Engineers Comments Regarding Surface Water Drainage

Application Reference:	LY/13/25/PL	Reviewer Reference:	ADC/EXT2/89
Planning Officer:	Amber Willard	Date of Review:	15/01/26
Site Name:	Back Arun Fishery North of Arundel Station Arundel BN18 9JJ		
Application Description:	Siting of 3 No. temporary structures and associated works. This application is in CIL Zone 3 (Zero Rated) as other development.		
Assessment Number:	1 of 2

Figure 2.2 - Existing Site Plan

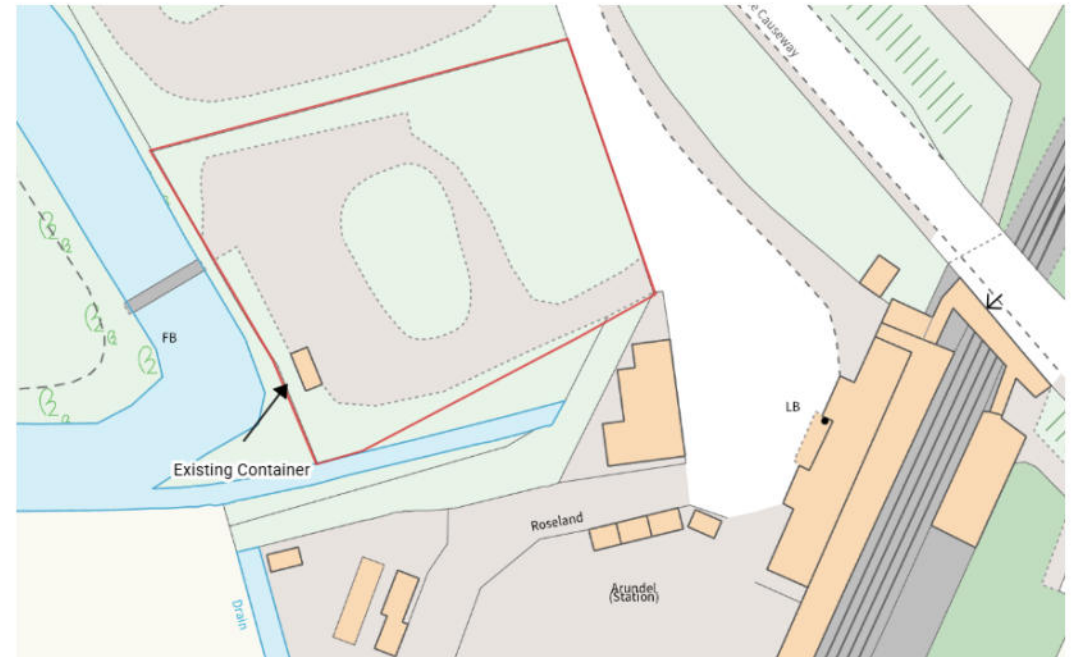
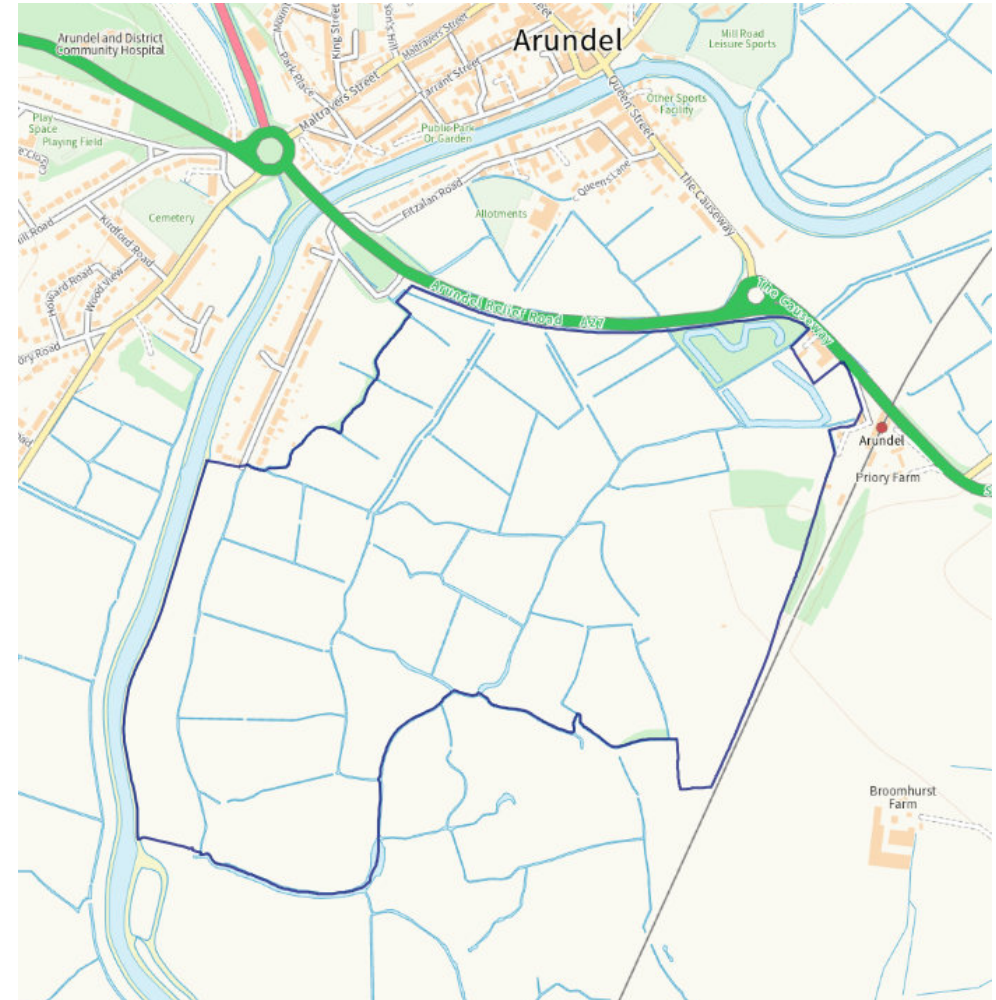
- 0.1. The FRA states in the section titled Surface Water Flood Risk Mitigation "The applicant has confirmed that the area where the proposed units will be installed is already underlain by hardstanding" Based on the drawings included in the FRA and satellite imagery, this does not appear to be the case.
- 0.2. It also states "As such it is considered that the development in its current form will not lead to a significant increase in surface water run off rates and volumes when compared to the pre-developed situation, and a surface water drainage strategy is not required". It then goes on to give advice regarding drainage proposals. Given that the proposed units appear to be located on areas that are

not currently underlain by hardstanding, and advice is given regarding drainage features, a drainage strategy is required showing that the proposals meet the requirement of the National Standards.
